Re planning document BE6317OUT
RE PLANNING DOCUMENT BE/63/17/OUT.

FROM FRANK DOWSETT.

Fig 2. Proposed Indicative Site Layout Plan

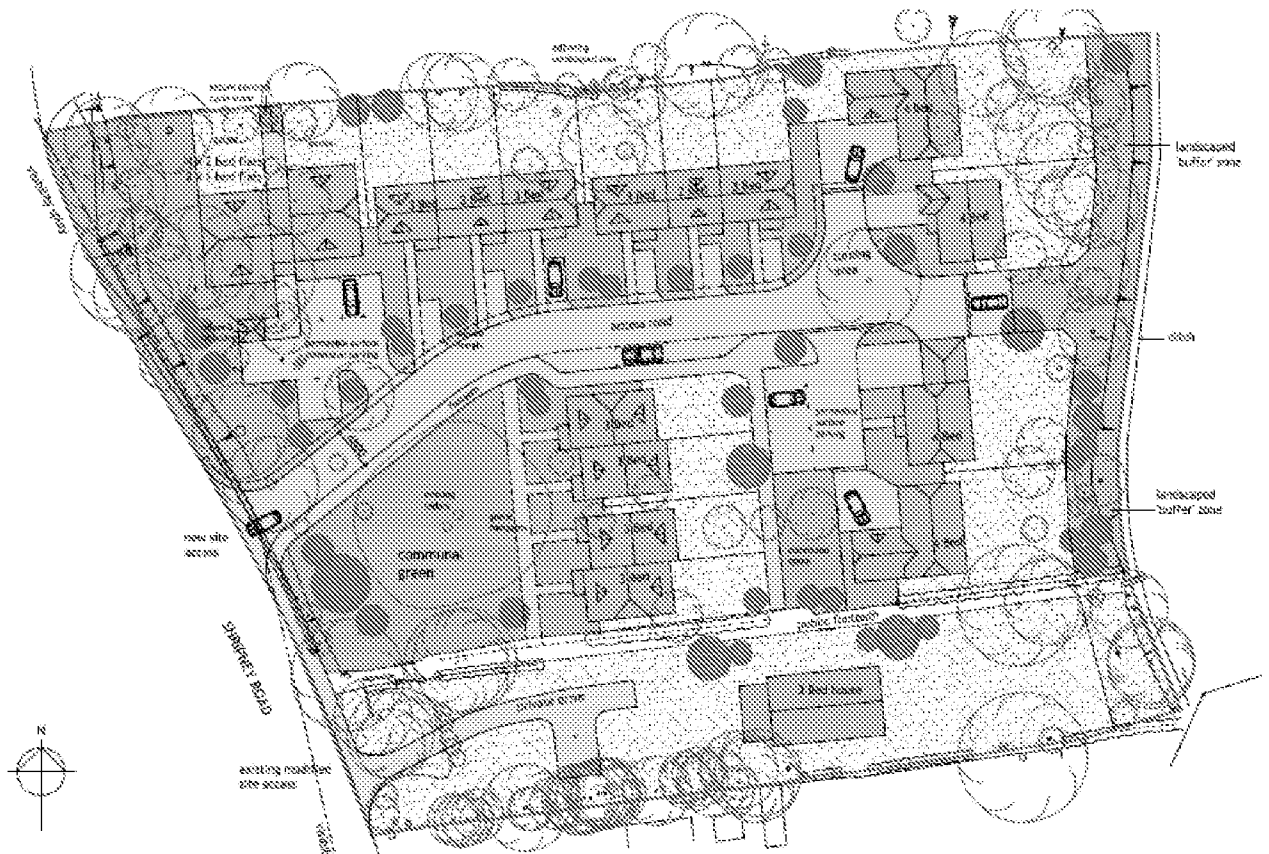
- 1) The exit onto the road would need to have a downward slope as the Robin hood has, the view northward is only about 30 metres, as there is a bend so traffic would arrive unseen, on average about 50 M.P.H. there has been a number of accidents due to traffic waiting to enter, or exit the Robin Hood and they do have a view each way from that point.

- 2) There is no access to install a footpath on that side of the road so vehicles and pedestrians exiting from the proposed site would be confronted with oncoming traffic, including about fifteen, eighteen wheeler lorries a day servicing all of the supermarkets, R011s Royse, and petrol stations, all of which we were told would come in via the new A259, and not through the five villages.

- 4) There would have to be off road parking for the new development as the service road opposite the proposed site where we live, is narrow and we park in our driveways such that the services/delivery vehicles can gain access when due, we have had access problems in the past with non residential parking.
